Planning Assessment Report

Application to Modify the Minister's Approval for industrial and business park uses at Greystanes Southern Employment Lands

Major Project 06_0181 Modification 2

## MASTERPLAN - Lot Plan

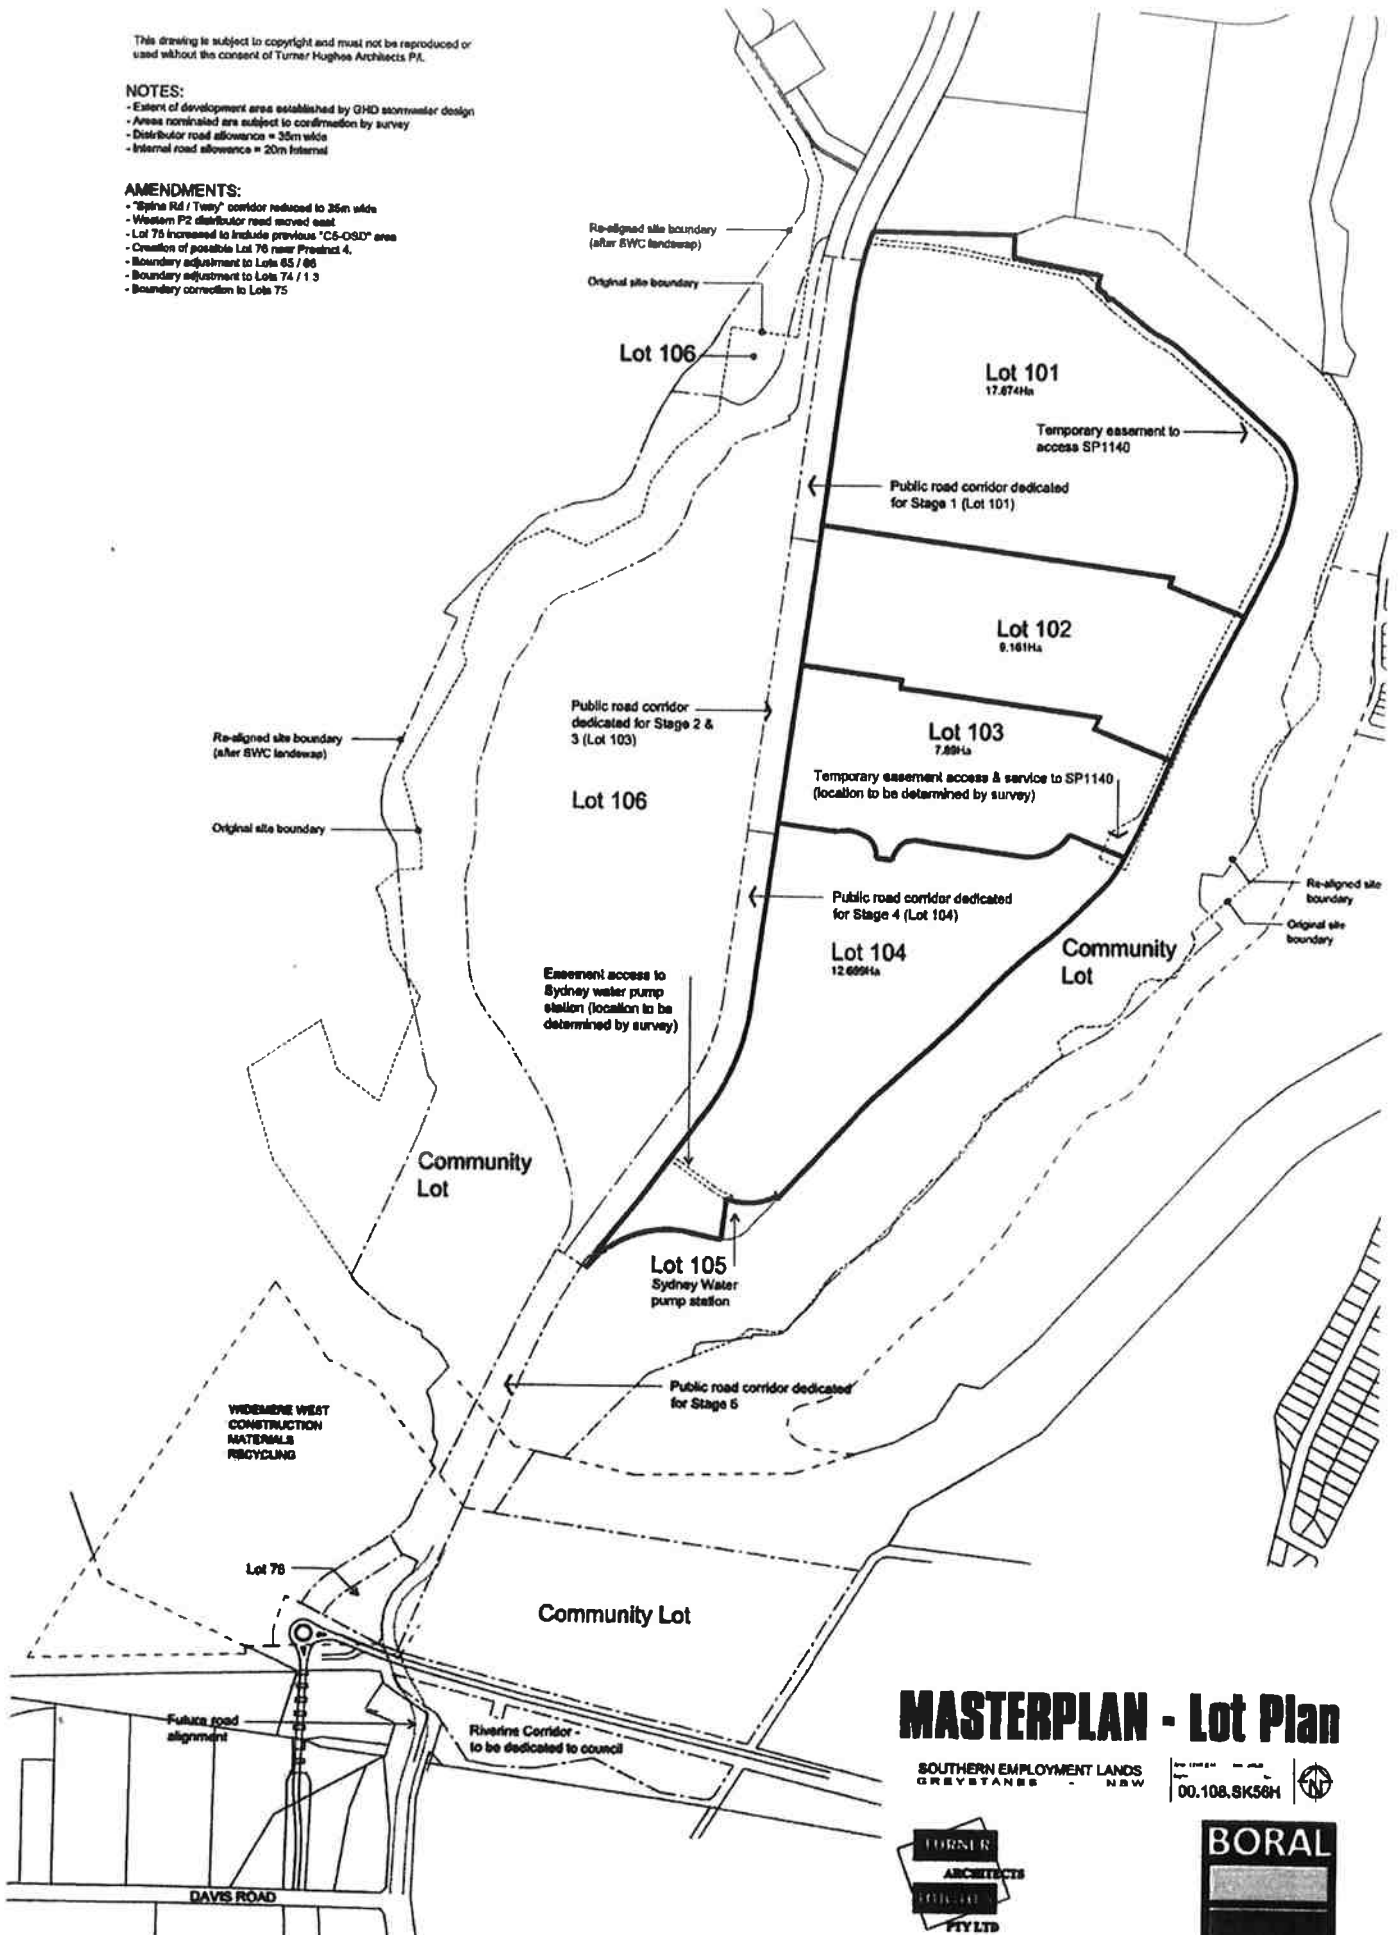
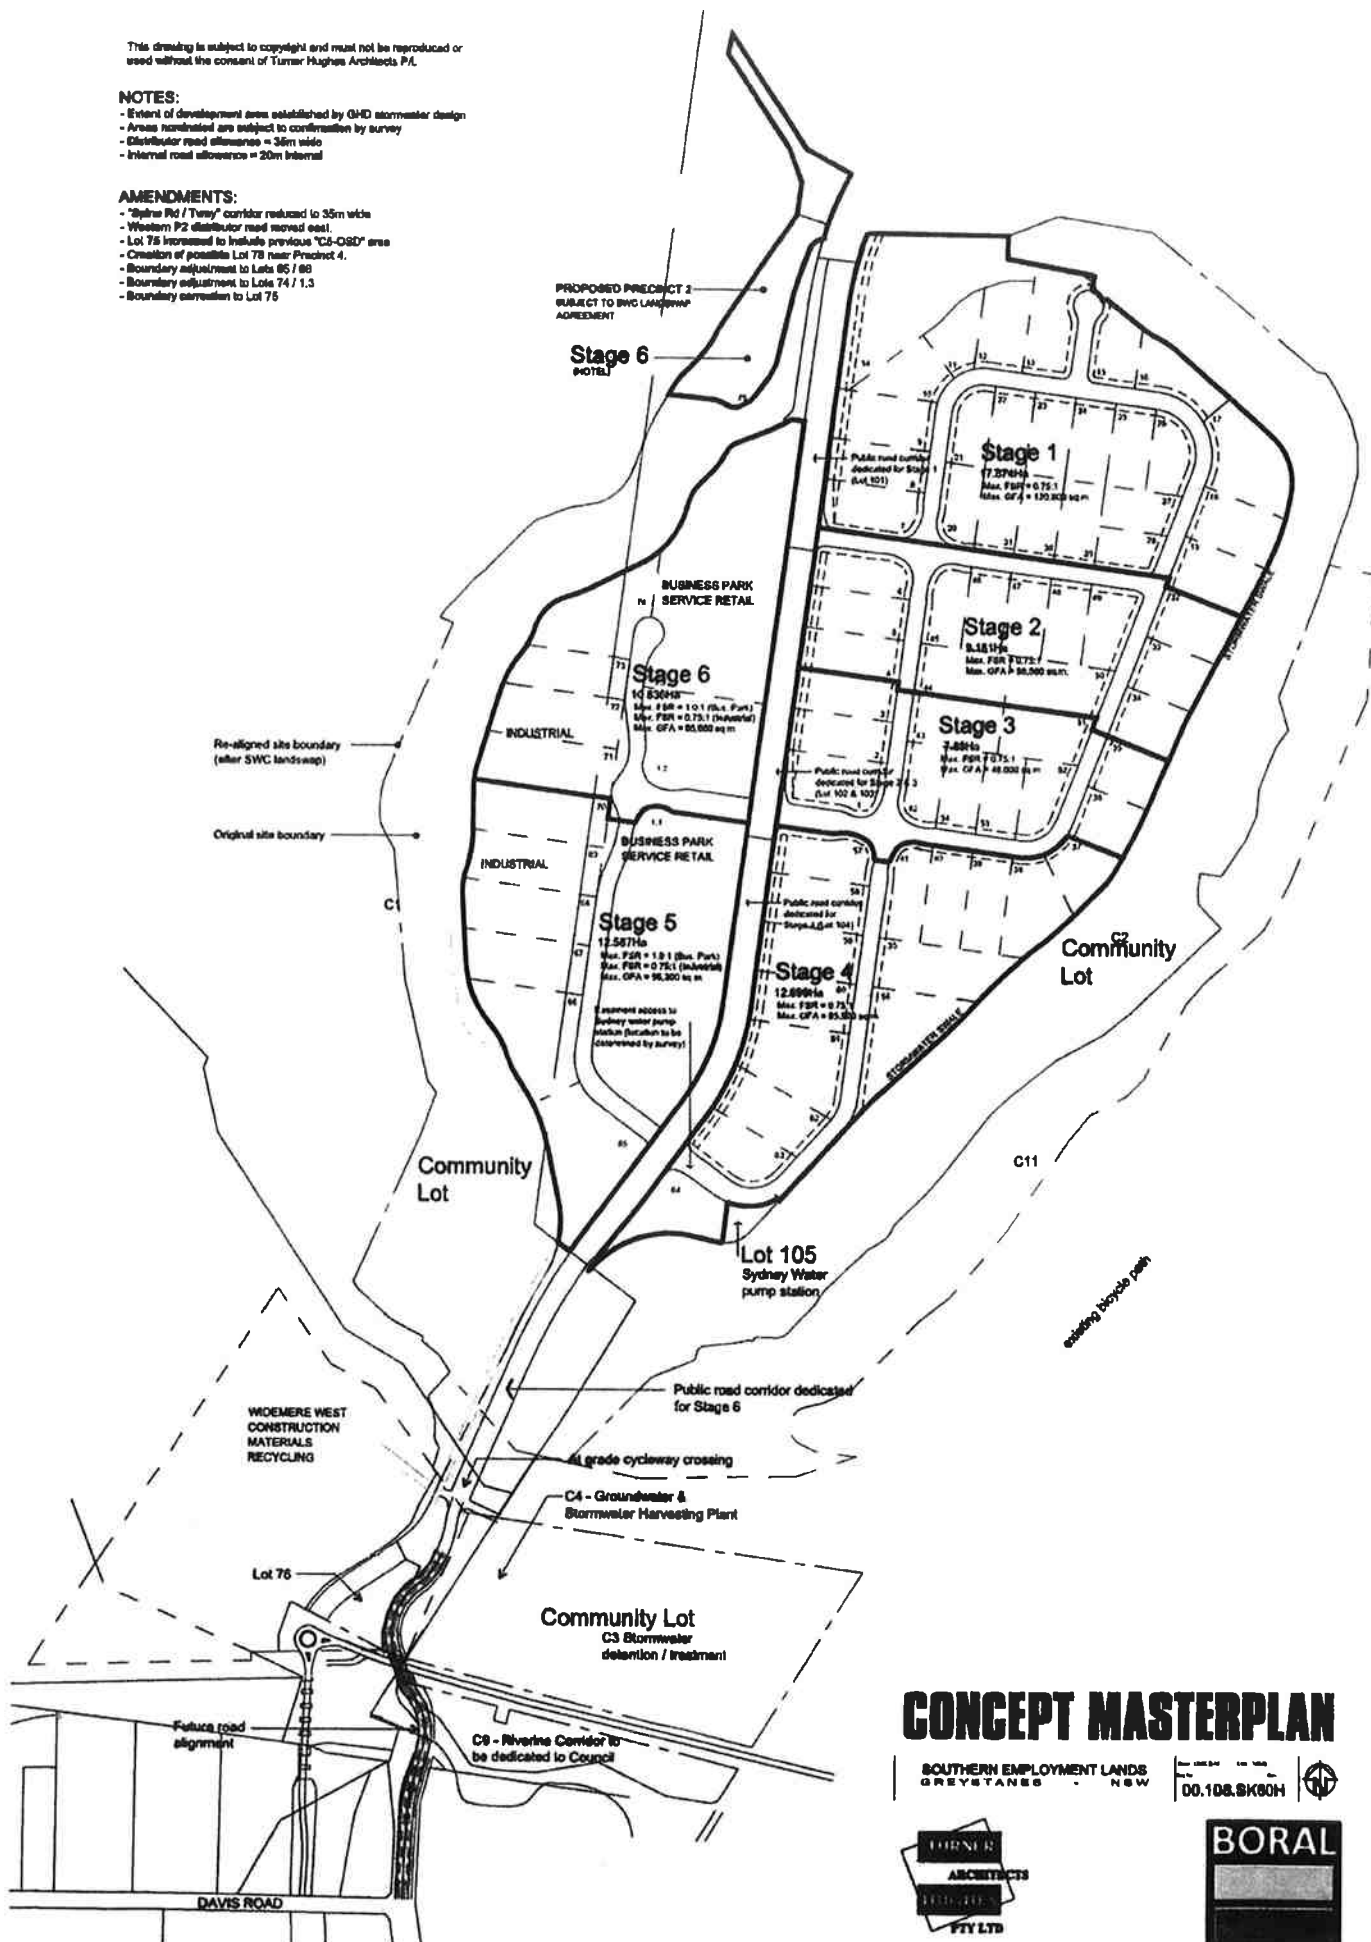
Fairfield City Council objected to the creation of proposed Lot 76 pending further details being provided to satisfy Council that the capacity and function of the stormwater detention facility has not been compromised.

Lot 76 is effectively a triangular island, bounded to west and south by the transitway and to the east by the spine road. Uses for this proposed lot have not been determined; Boral's application notes potential uses such as for signage or entry statement to the Employment Lands. Access to this proposed lot would be restricted to left in-left out from northbound lanes of the spine road.

It is accepted the lot is not required for stormwater purposes. The future use of the lot is not part of this application; however, it is appropriate that the Urban Design Plan for the Greystanes Southern Employment Lands be amended to establish development controls for this lot; this will be required as a condition of modification. The creation of the lot itself is of no environmental planning consequence and is appropriate to approve.

Side Boundary between Lots 65 and 66 – the boundary between these lots, which are proposed for use as “Business Park/Service Retail”, currently runs north to south along the local government boundary between Blacktown and Holroyd. It is now proposed to run the lot boundary along a stormwater line between the lots (south west to north east). Neither lot is significantly affected in size. Whilst this boundary alteration was initiated by the proposed adjustment of the transitway corridor and consequential increase in lot sizes of the westernmost lots, that issue, which is considered elsewhere in this report, has no bearing on the Lot 65/66 boundary. The proposed adjustment of this boundary is of no environmental planning consequence and is appropriate to approve.

Lot 75 – the proposed adjustment to this lot (which is proposed for use as an hotel) involves decreasing the size of the lot along its northern boundary to reflect a land swap with Sydney Water Corporation and increasing the lot size along the eastern boundary to butt up against the spine road (slightly reducing the size of the Community Lot in that location). This lot's shape reflects its physical awkwardness, being located on the western batter wall of the former quarry. The boundary adjustments are of no environmental planning consequence and are appropriate to approve.

# PLAN REF SK0056 REV A

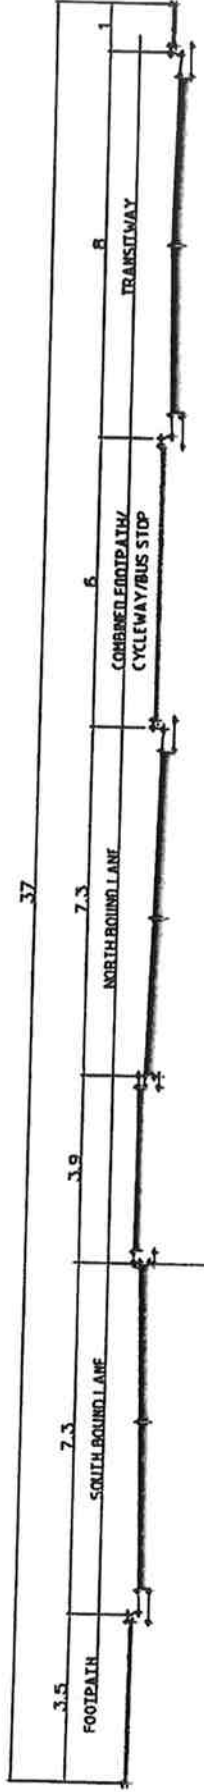
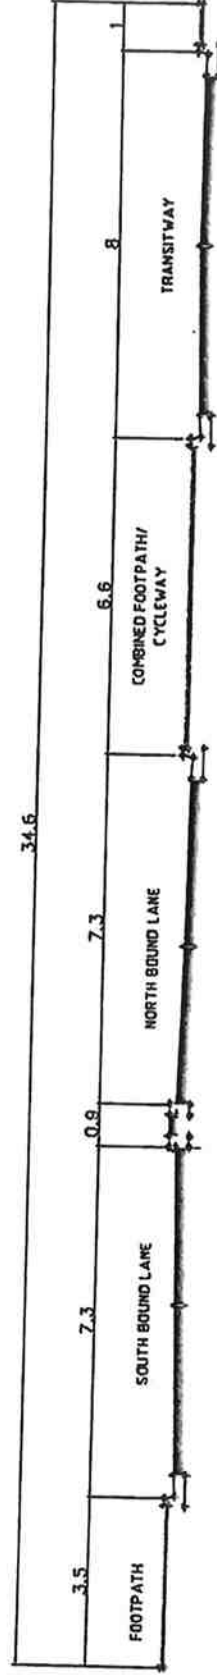
Boral now proposes to reduce the width of the transitway corridor by 15 metres; the corridor would provide for an 8 metre wide transitway, with additional area for footpaths and cycleway, as outlined in Annexure E of the modification application. Boral will undertake bulk earthworks and formation of the transitway corridor, however, Boral is not responsible for the future construction of a transitway.

The reduction in the width of the transitway corridor generally reduces the width of the central public road corridor (4 lane roadway and transitway) from 50 metres to 35 metres (although the reservation will be broader at bus stop sites). This reduction maintains the originally intended road lanes and functions, cycleways and footpaths, however, reduces the amount of roadway landscaping.

Holroyd City Council, in which area the road corridor is located, objects to the elimination of landscaped area from the road corridor and notes the reduction of width may reduce flexibility of the road configuration. The Council supported the original concept of creating a landscaped boulevard and regards the current proposal as a "substantially poorer urban outcome".

Whilst the current proposal will reduce landscaping, it is also noted that the spine road plays a primary utilitarian function in the servicing of the employment lands. In this regard, roadway landscaping, as originally proposed, is a discretionary and non-essential element. Considerable landscaping will be provided alongside the spine road, within the curtilage of industrial and business park allotments and along local roads within the subdivision. The Department is concerned to ensure the employment lands are made available in the most efficient manner, including maximising available area, flexibility of layout and reduction of unnecessary costs.

The Department considers that the narrowing of the transitway corridor will not adversely affect functionality or safety and may properly be supported.

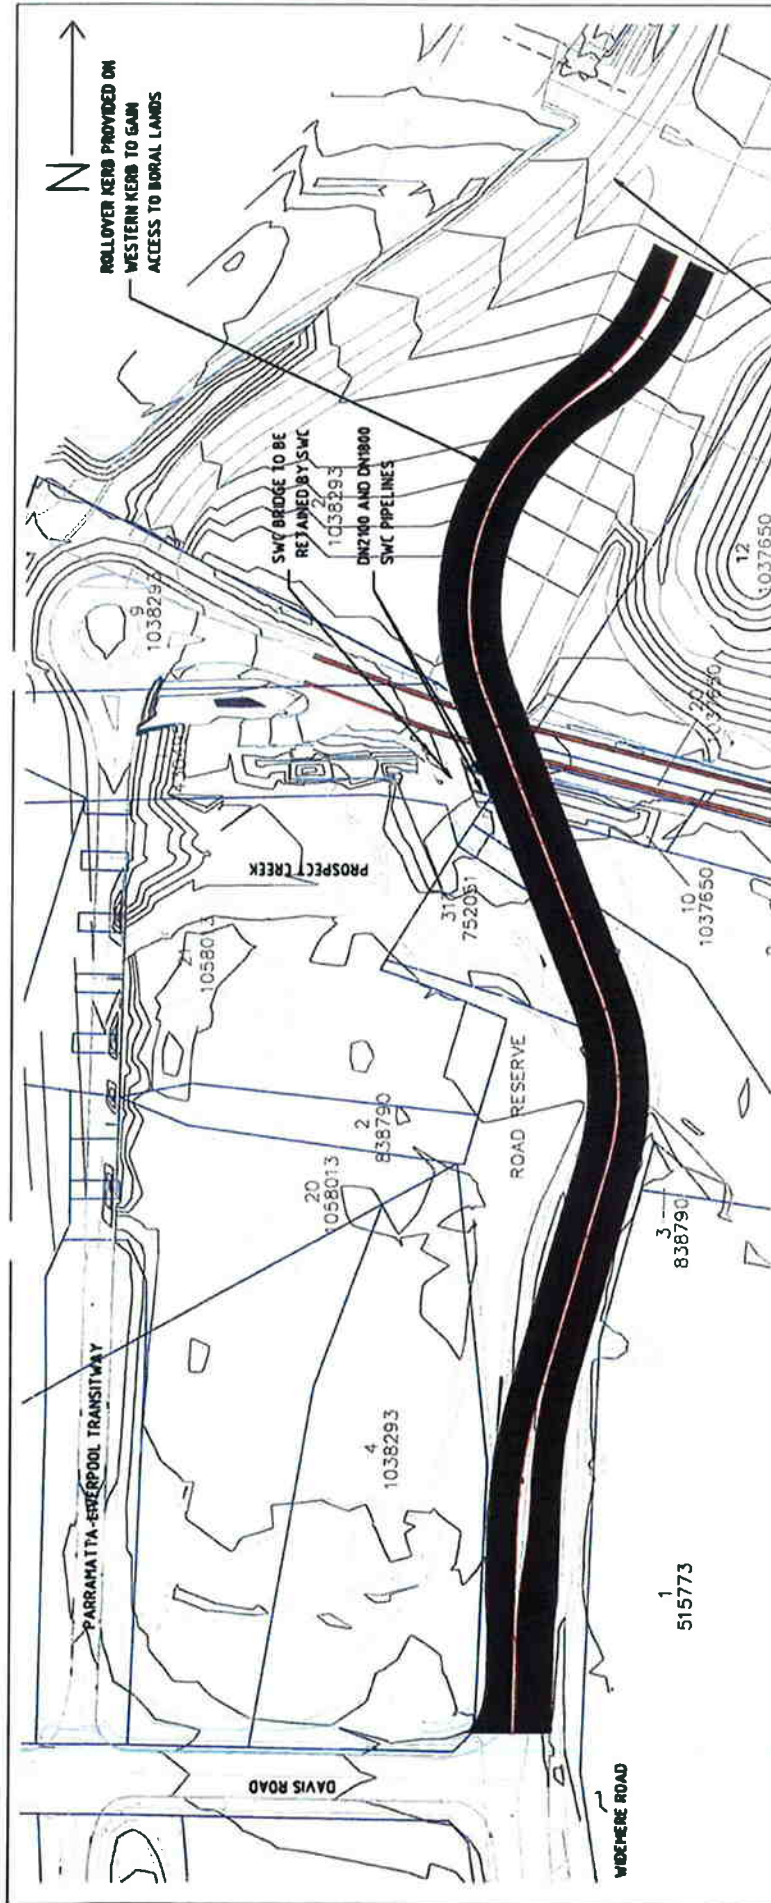
The alignment of the proposed Southern Road Connection is shown at **Annex D** of the Modification Application (**Tag C**) (Drawing 5696-SK-0048 Rev F). Commencing from the southern cut of the old Prospect Quarry the SRC will cross the Liverpool-Parramatta Transitway at grade at a signalised intersection, then cross the Sydney Water pipelines (providing a 2 metre clearance) then grade down to a low level bridge crossing of Prospect Creek and then join Davis Road at its current intersection with Widemere Road.

Prospect Creek is flood prone in the location of the proposed crossing by the SRC. The current southern access road (which is an informally made road used to serve as quarry access over many years) floods frequently (estimated 3 times per year) with a flood depth of 600mm for a 1 year ARI event. Fairfield and Holroyd Councils have expressed concern and objection regarding the impact of the road on flooding and public safety. Fairfield Council sought the SRC be constructed above the 1 in 100 ARI flood level.

The design of the SRC has been subject of considerable scrutiny between the Department and Boral. The SRC now proposed represents a far superior and more sustainable design than was earlier conceived and a substantial increase in commitment by Boral to its construction cost. Design specifications now proposed for the SRC provide that the road will have flood immunity up to a 100 year ARI event; this represents a marked improvement on the current flooding regime.

The Department accepts the design parameters which are proposed for the SRC to meet and notes these represent an improvement to the flooding status quo and over preliminary designs. The Department notes that Fairfield Council has recently advised its support for the revised SRC design.

Approval of the modification will allow further development of road design and flood modelling. The Department recommends that final designs be required to be verified as to their performance against the specified criteria, as well as being submitted to the Fairfield Council and the Department of Planning for comment, prior to the issue of a construction certificate.
